# MDT-PPR21008-R1-SDP-redlines.pdf Markup Summary

**Subject:** SW - Text Box  
**Page Index:** 1  
**Date:** 3/24/2021 4:42:49 PM  
**Author:** EPC Stormwater - Glenn Reese  
**Color:** ■  
**Layer:**  
**Space:**  
**Page Label:** 1

Add text:  
PCD Filing No.:  
PPR-21-008

INITIAL EROSION CONTROL PLAN		COLORADO
SUPER STAR CAR WASH - FALCON MARKETPLACE LOT 10		EL PASO COUNTY
SITE DEVELOPMENT PLAN

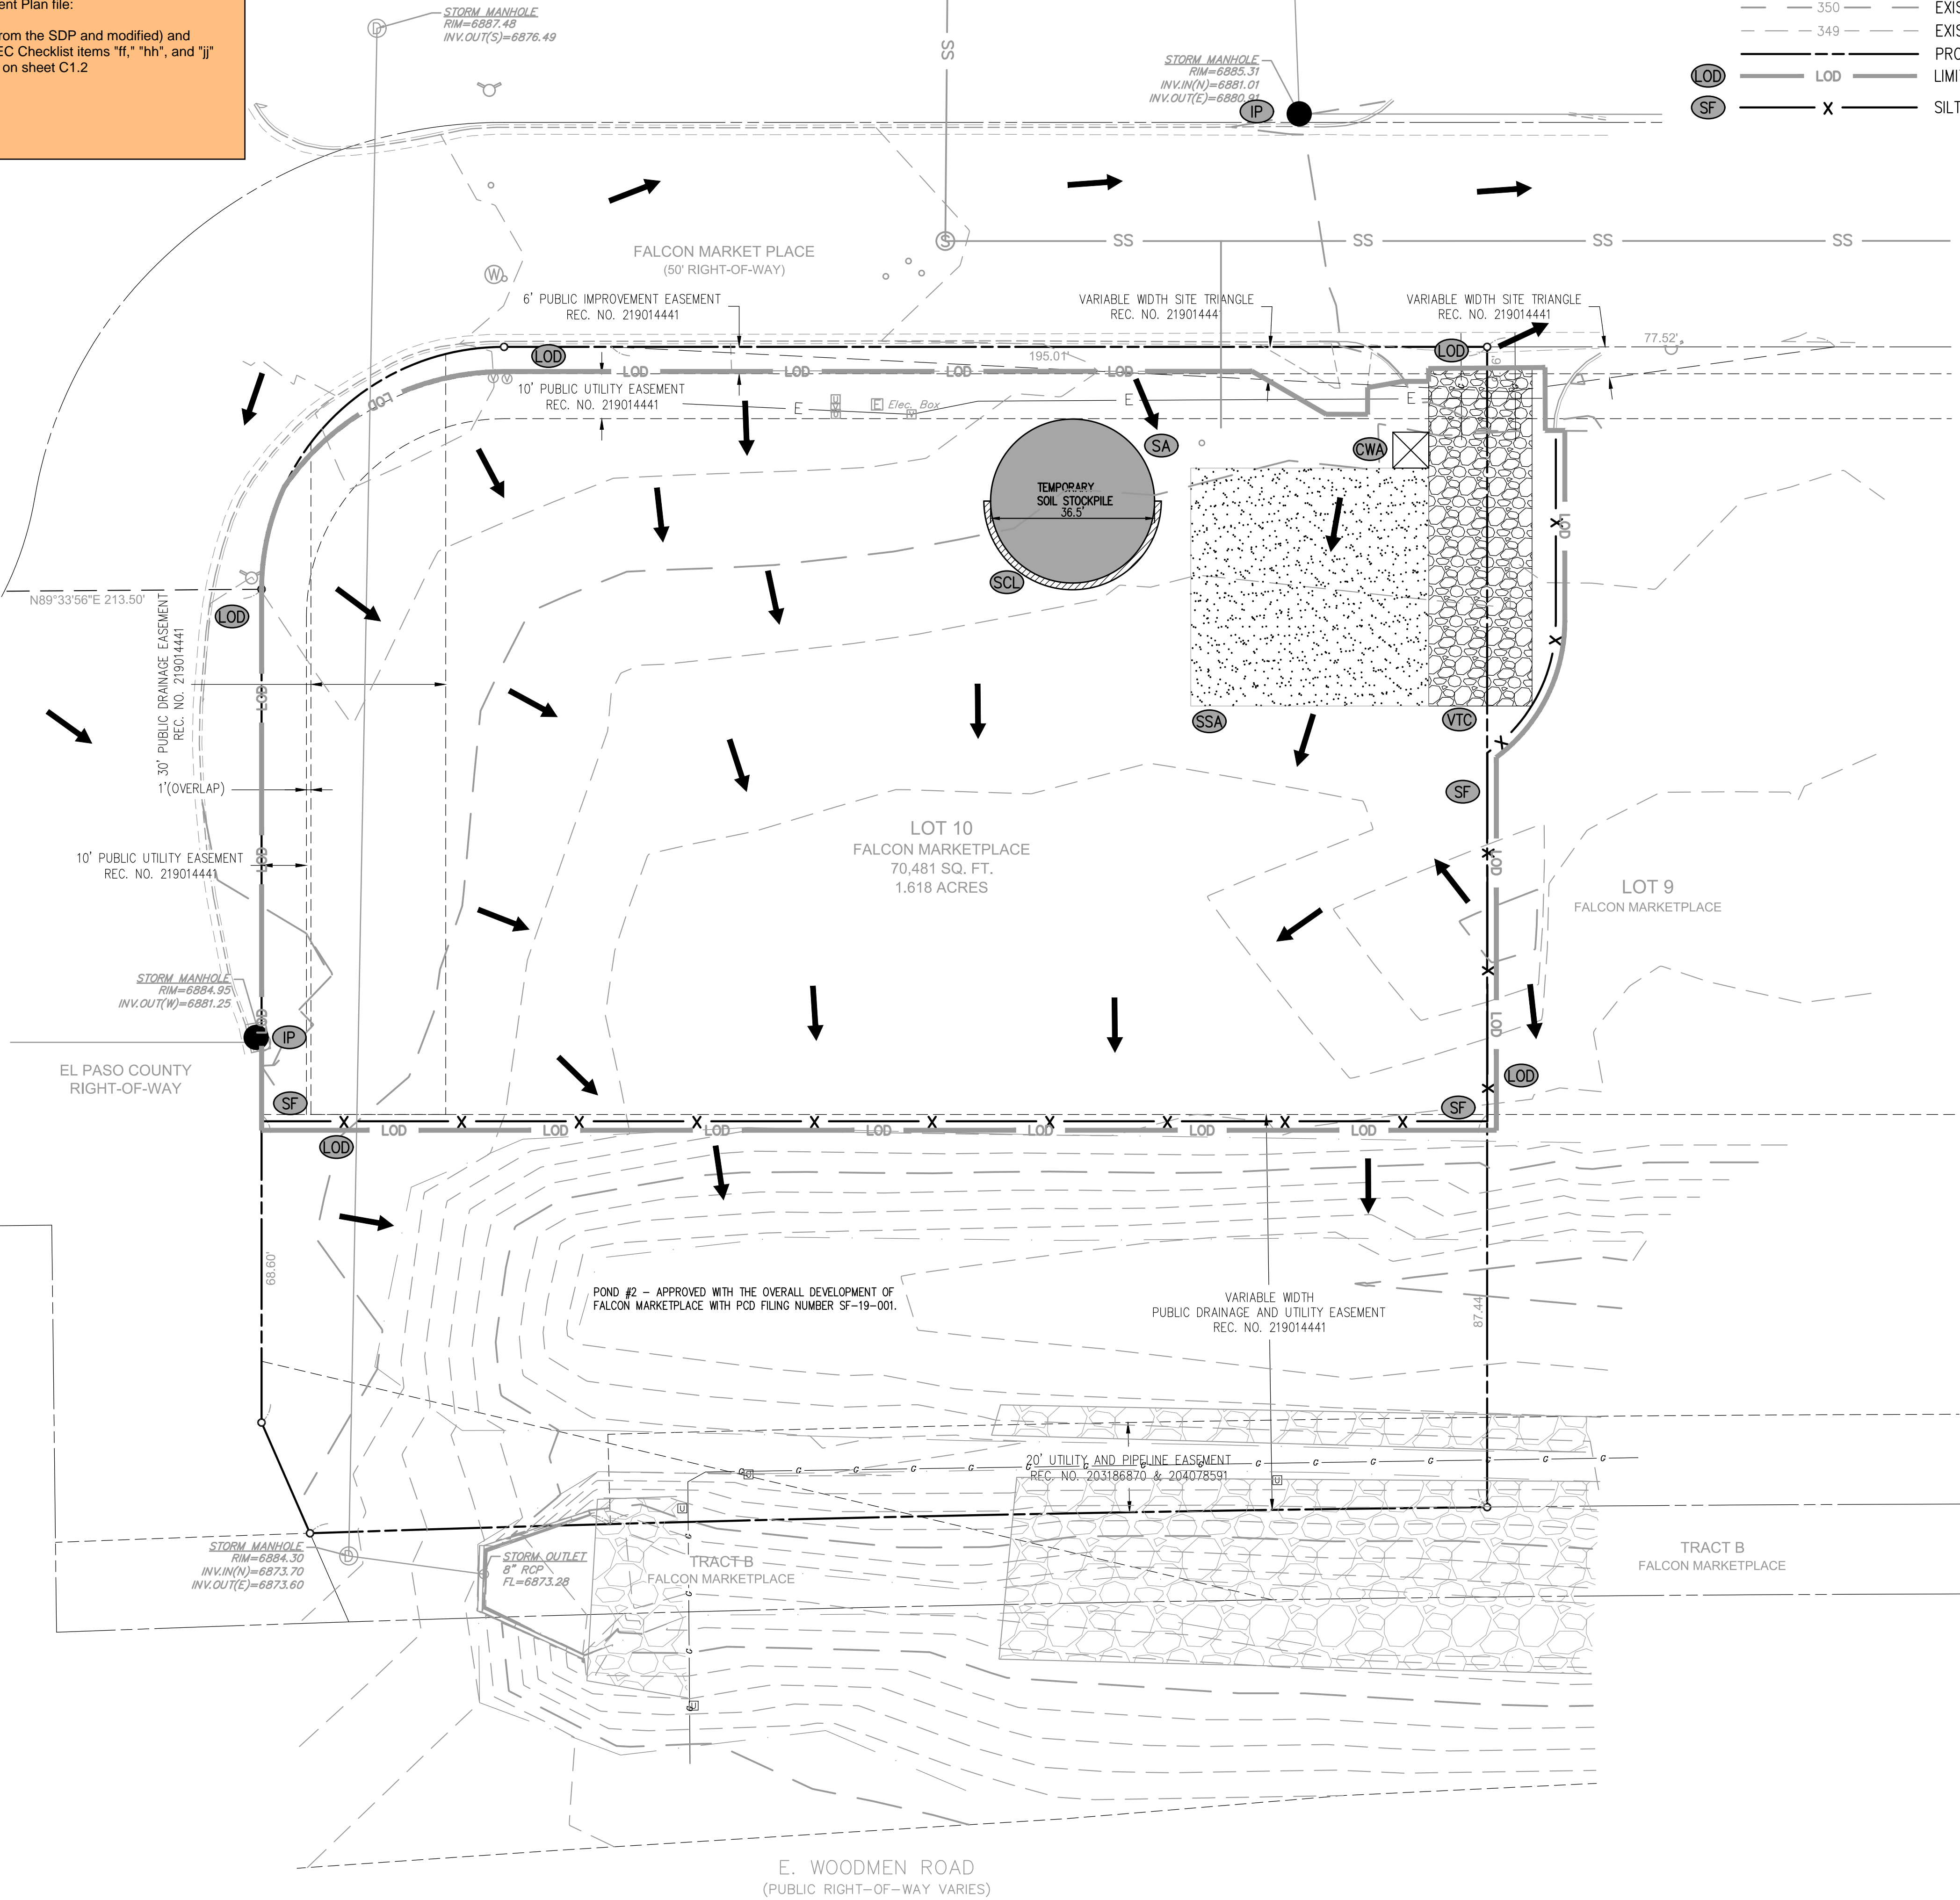
- Checklist Item B - label the surrounding subdivision names, lot #'s, and/or parcel #'s
- label adjacent roads.
- Checklist Item H and M. If "limits of disturbance" and "construction boundary" are the same, change to "construction boundary/limits of disturbance" or otherwise show as separate linetypes for each on the legend and figure.
- Item I - include a note on here (or on Sheet 2 - General Erosion Control Notes) about condition of existing vegetation.
- show offsite drainage flow arrows as well
- Item P - identify areas of cut/fill. A note descriptive note is acceptable. For examples: the site is mostly cut or fill, or cut/fill in northwest corner, or site was previously graded with the rest of the overall development of Falcon Marketplace.

DESIGN	DRAWN	CHKD
SWK	SWK	TOP
SCALE	H: 1" = 20' V: 1" = XXX'	
JOB No.	020441-01-001	
DATE :	02/09/2021	
SHEET	C3.0

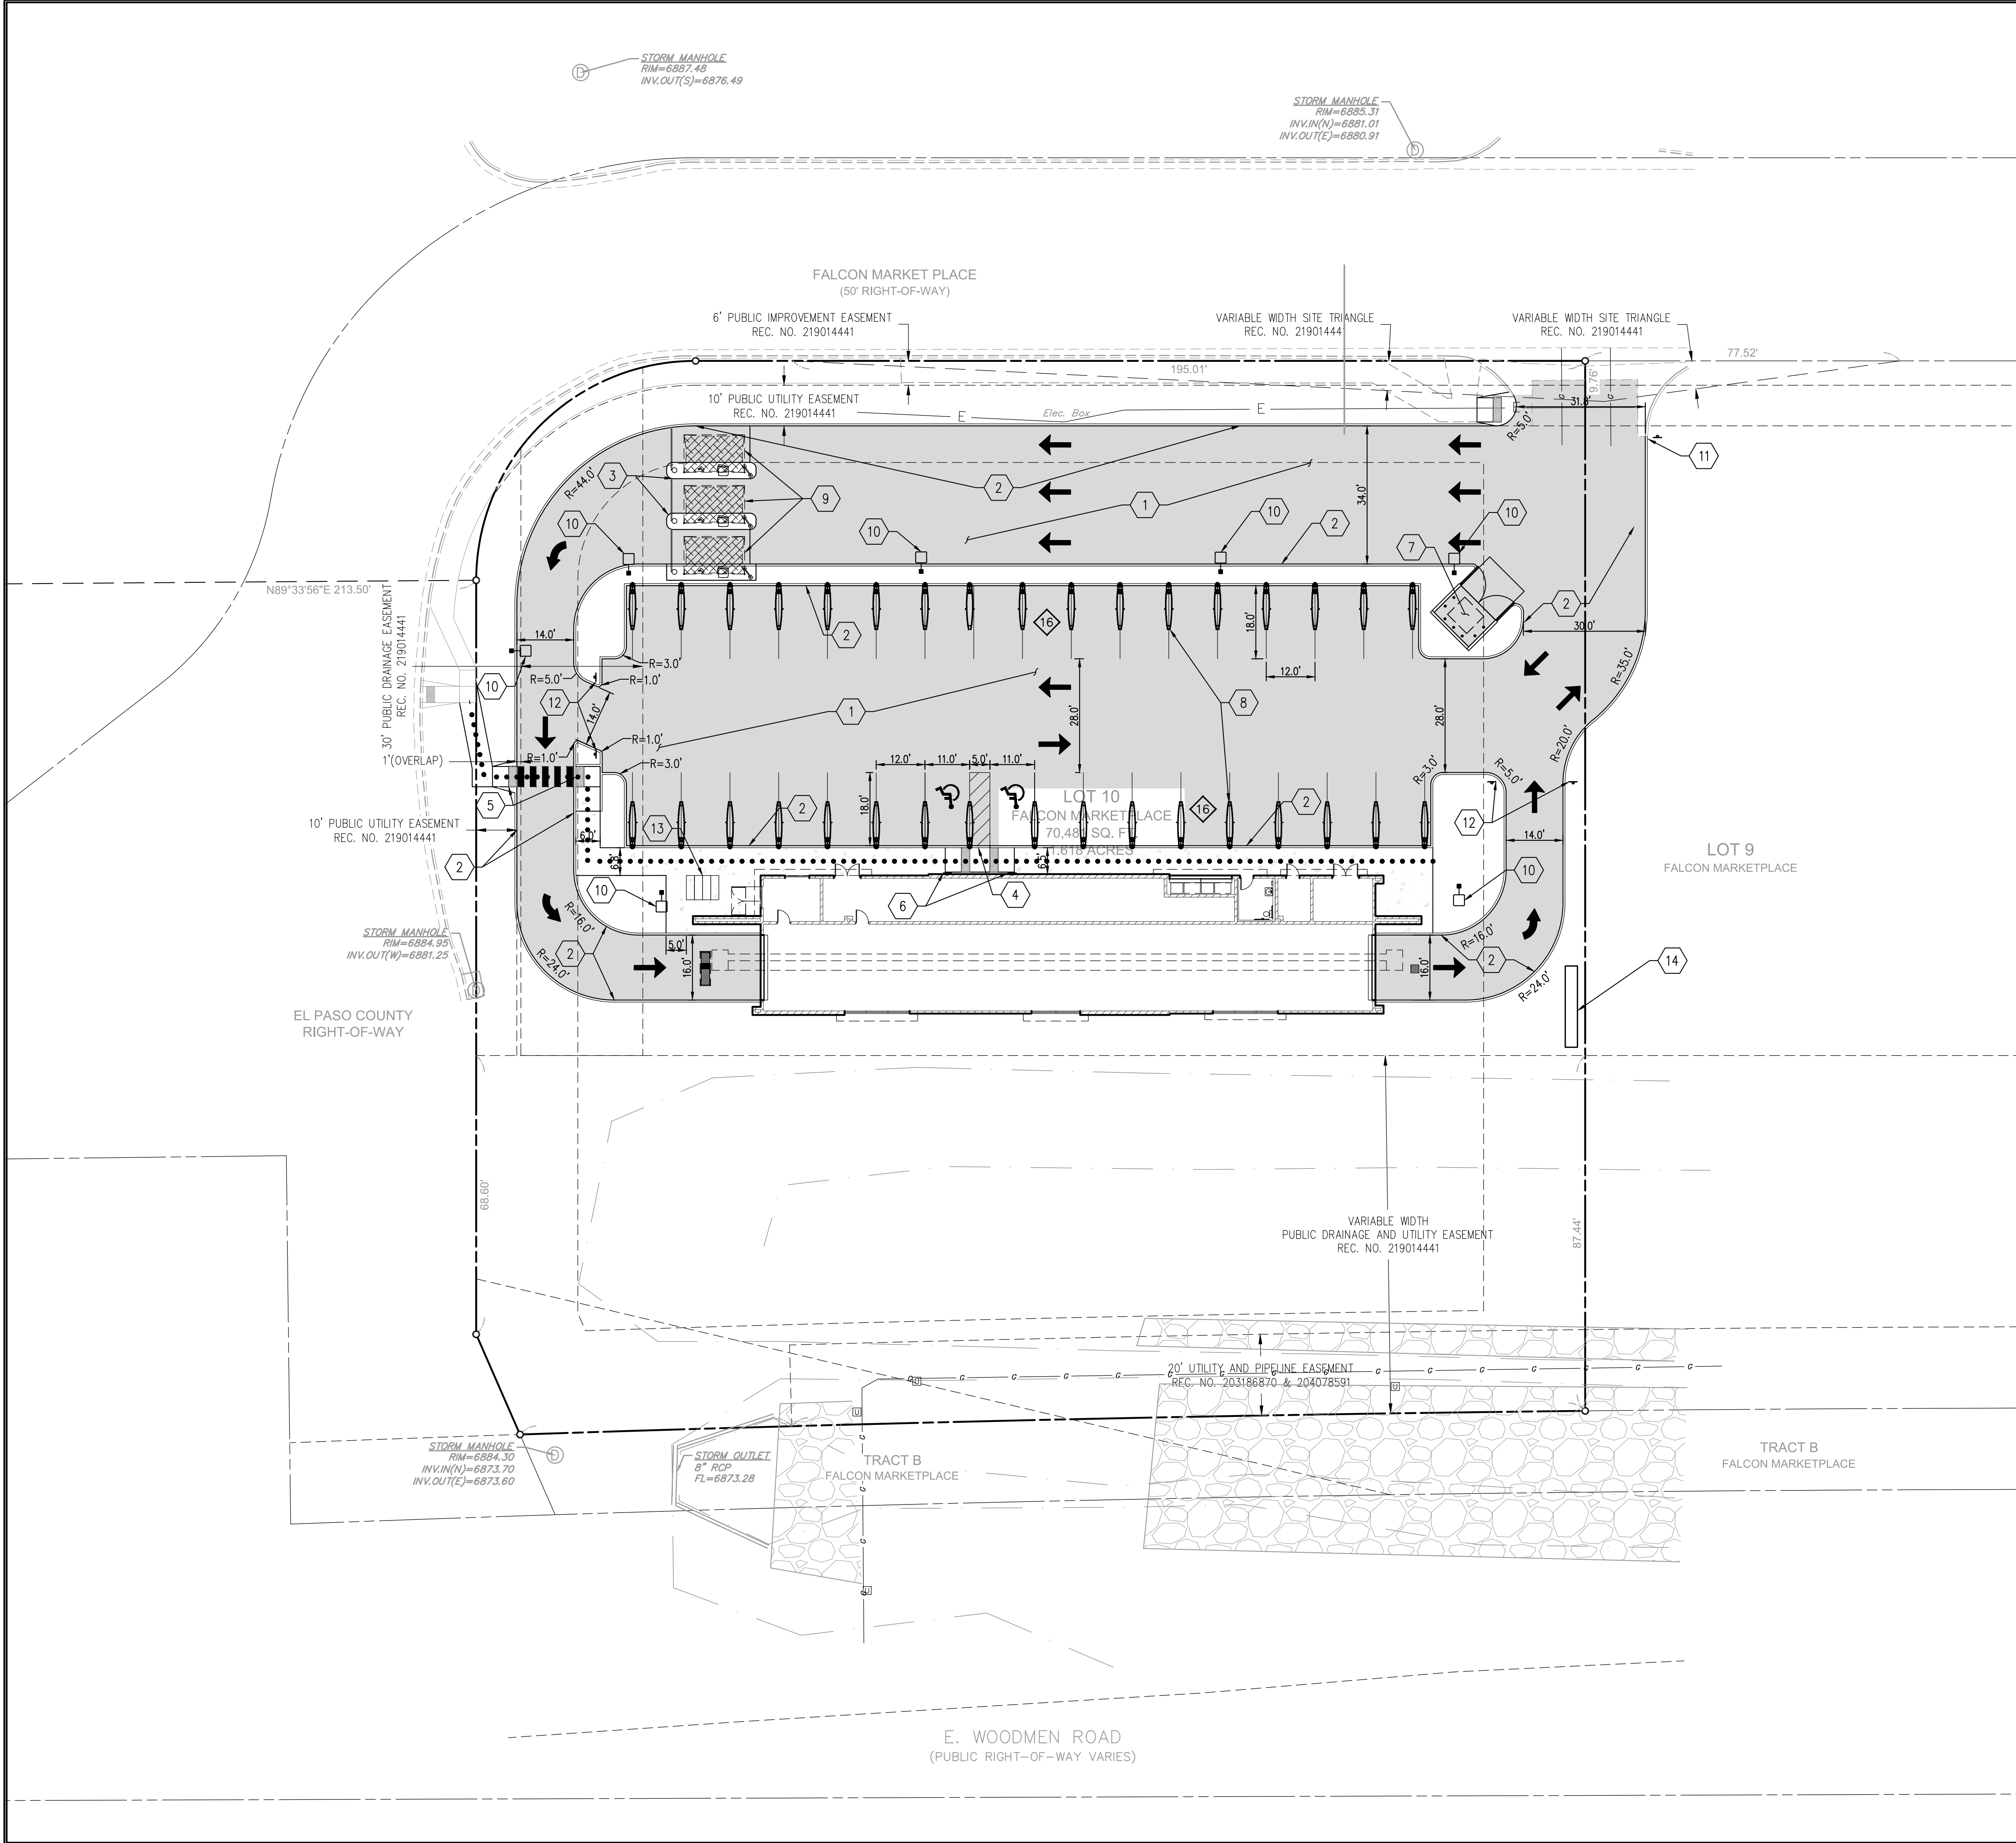
Please add and callout an ADA accessible route from parking spaces to building/throughout site.

Also, one parking island is required per 15 or fewer spaces.

Per LDC Table 5-5 footnote 4, canopies must be setback from all property lines by 25 feet. Please show setbacks to ensure compliance with this requirement, or revise accordingly.

Please dimension ingress/egress width.

Please show easements per approved recorded plat (snip showing easements below). Please also show any applicable easements referenced in the title commitment that was submitted (there are a few easements conveyed to MVEA and an easement for Diamond Shamrock gas pipeline company).
